DECISION DELEGATED TO DEVELOPMENT MANAGER

Application No: H04-0445-20 **Applicant:** Cook Property Holdings Ltd.

Proposal: Details of site levels, contamination ground report, materials, surface water drainage, landscaping, boundary treatment, storage of waste bins and external service boxes (Conditions 3, 7- parts i and ii only , 8, 9, 10, 11, 12, and 13 of H04-0894-17)

Location: Dave Cook Engineering Quadring Road Donington

Date	April 2020	Scale @ A1	1:200	Drawn	TRS
Drg.No.	8981-107			Rev.	A

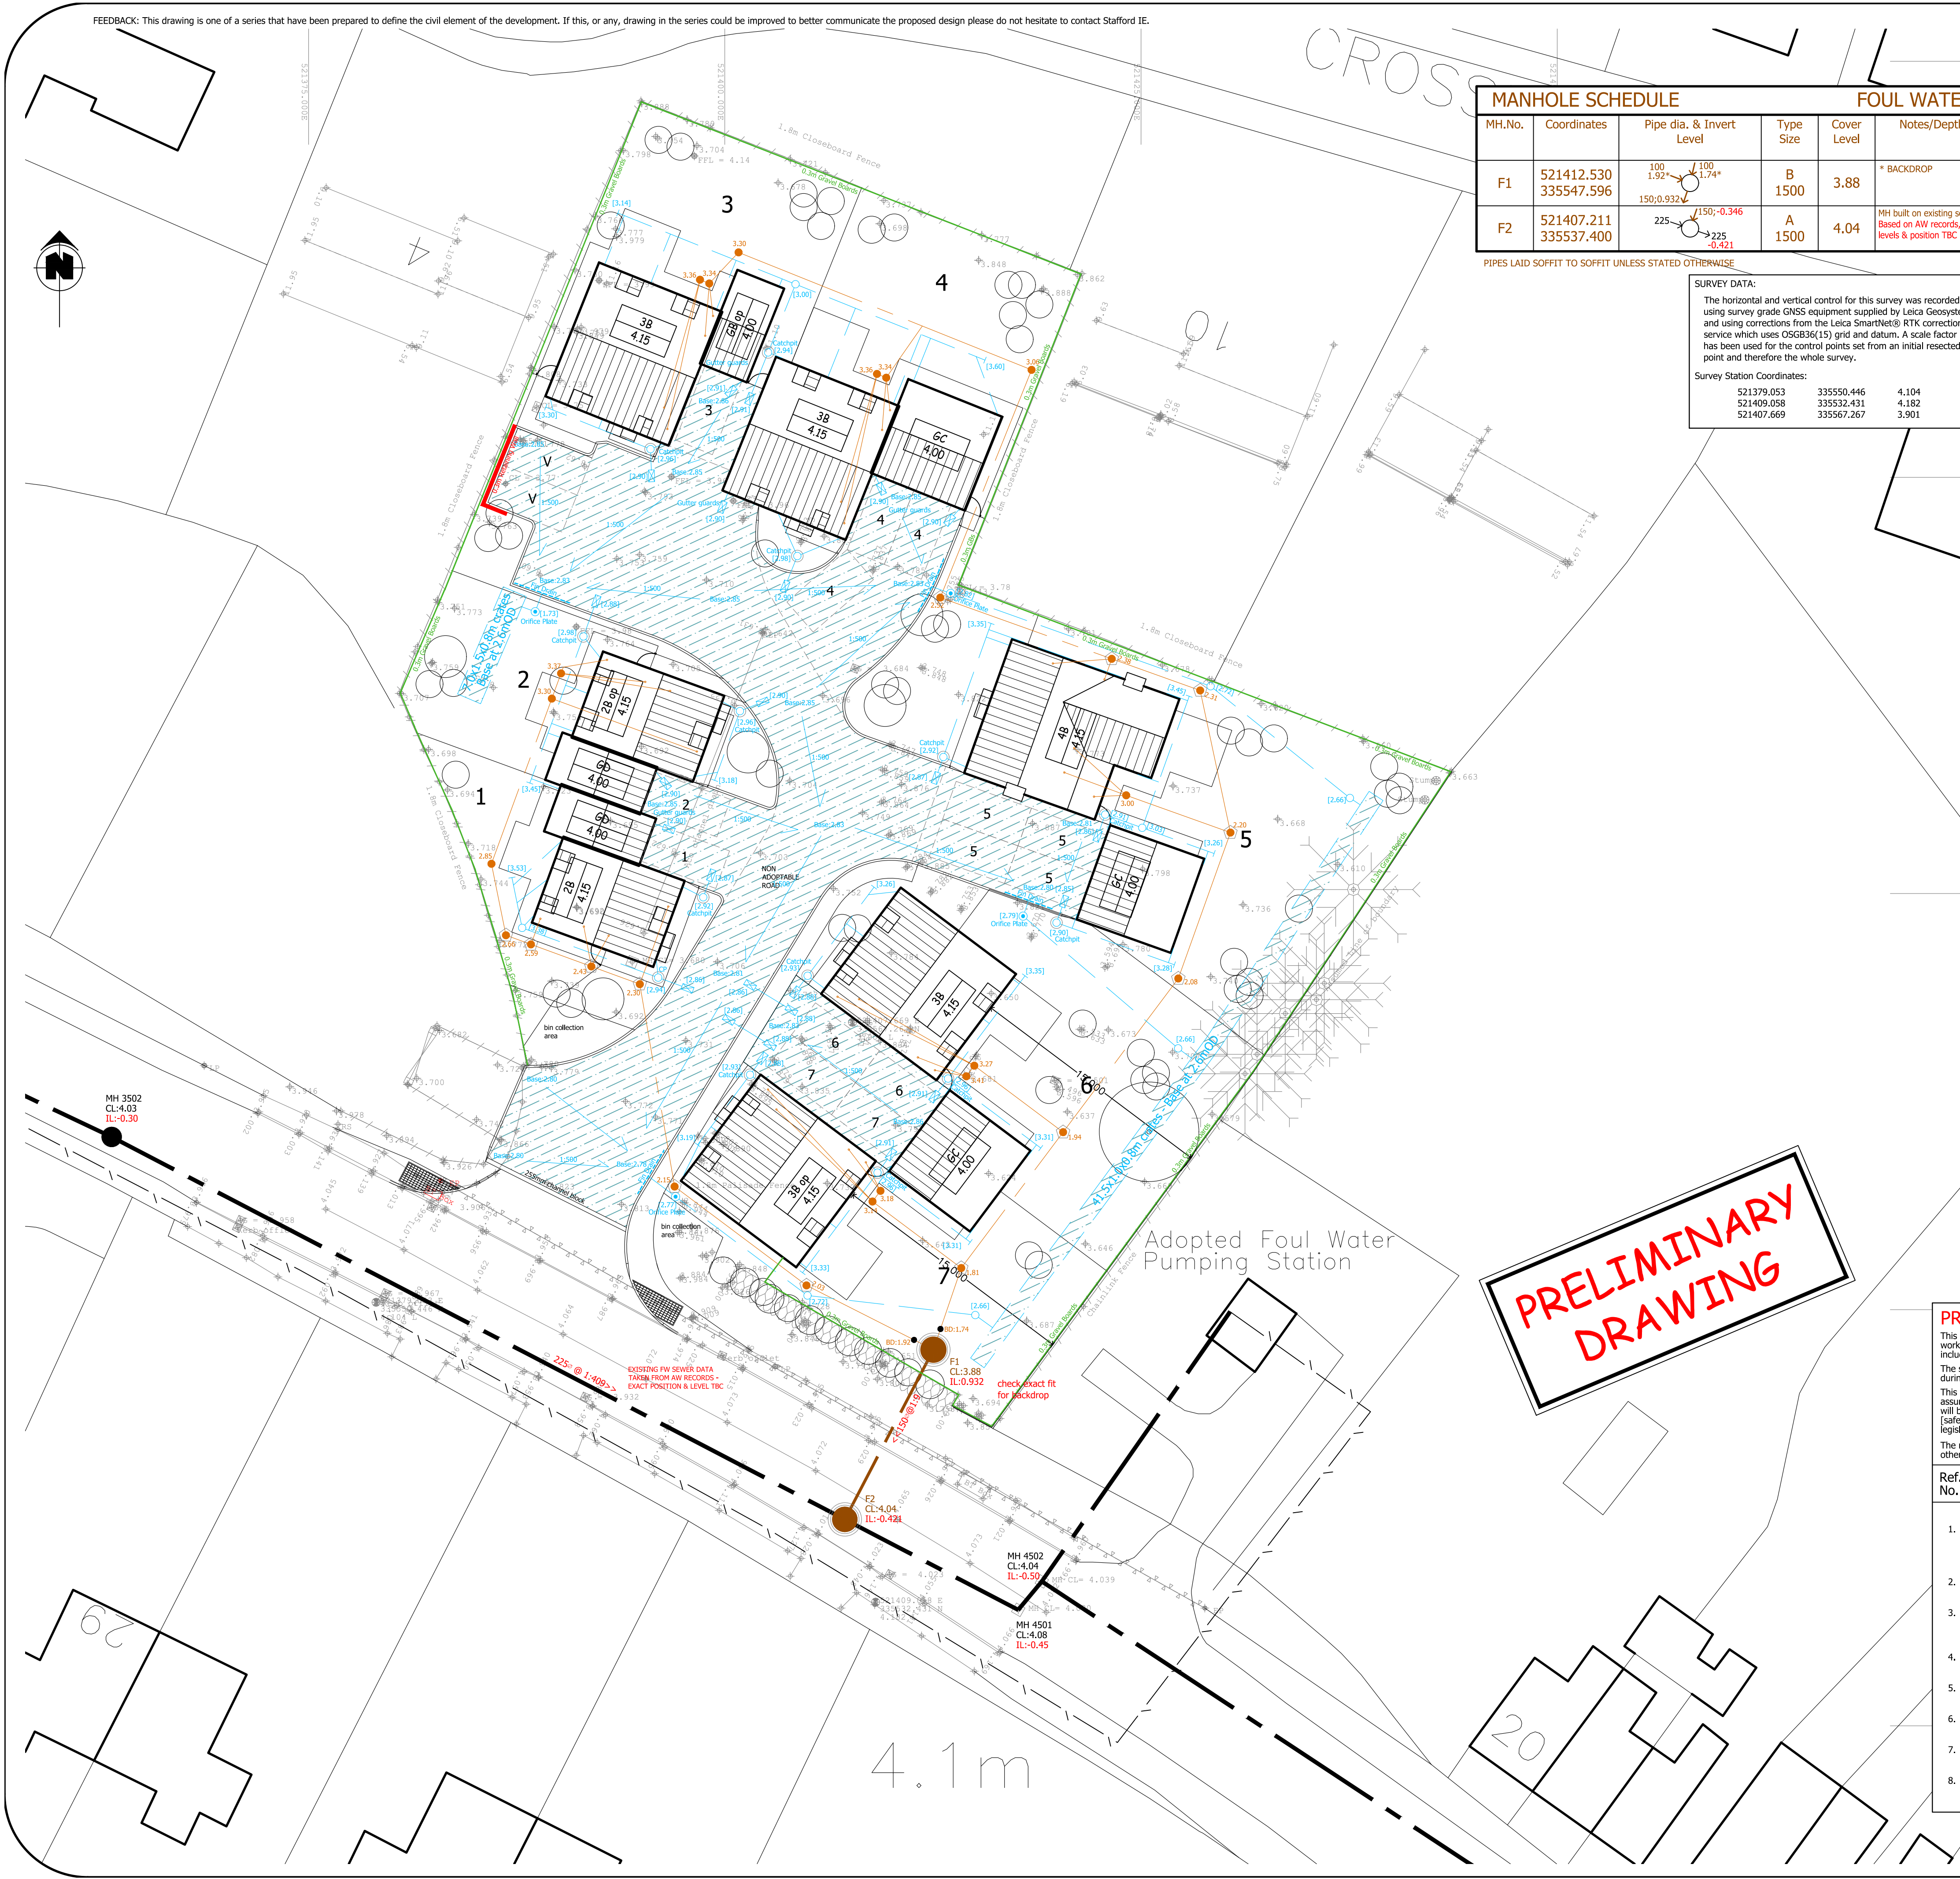
The Black Sluice Internal Drainage Board have responded "Surface water - it would appear that the applicant intends to use soakaways/infiltration as the means of surface water disposal across the site. However, the Board can find no evidence submitted to the LPA (as the approving authority) to prove that soakaways/infiltration will be suitable for the site. Until such evidence is presented, the Board deems that the surface water scheme is unsuitable until proven otherwise. If soakaways are subsequently proved unsuitable, then the applicant must submit full details of an alternative scheme to the LPA for consideration. Discharge into any watercourse, open or piped, will require the prior written

consent of the Board." The location and efficacy of the soakways would be a matter assessed by the Building Control section. The flow of surface water and permeable pavement would appear to aid through flow and quick dispersal of water at times of heavy rainfall.

Hard Landscaping

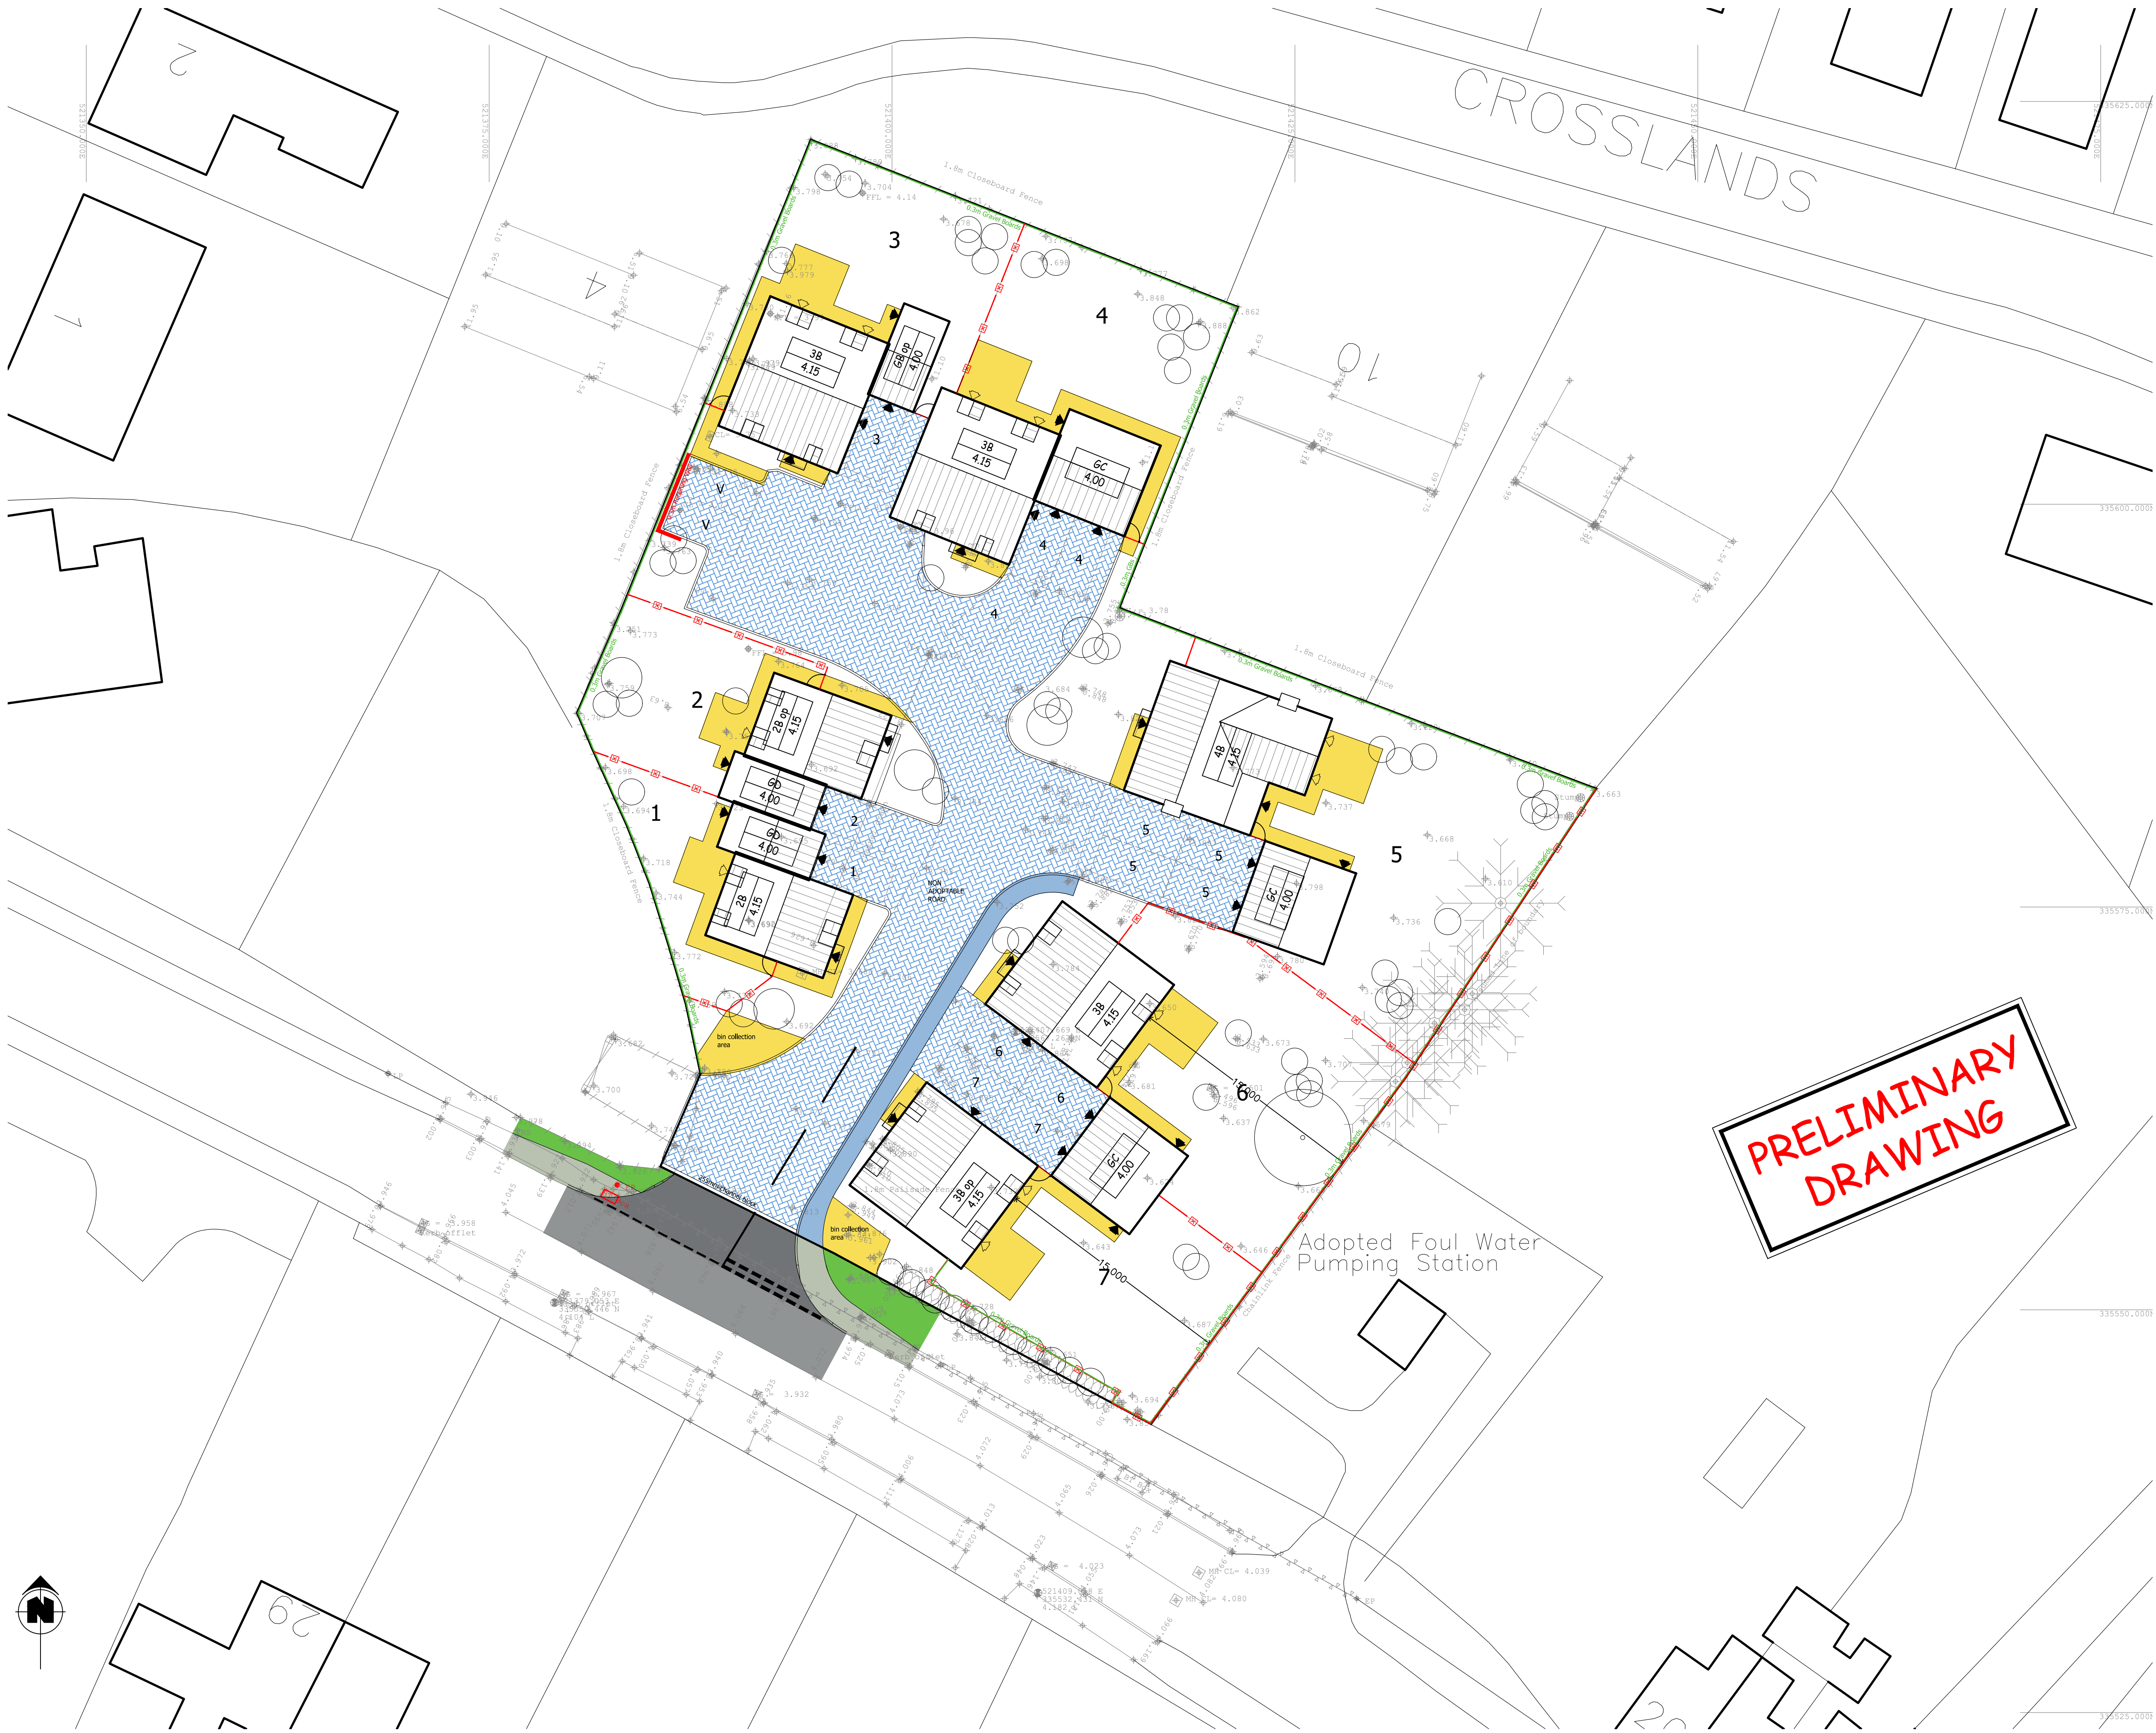
Refuse storage is provide on each property with bin stores either side of site entrance for disposal on collection days. The locations whilst visually prominent are now common amongst private road developments and are not considered to impact highway safety or visual amenity. This condition can be discharged
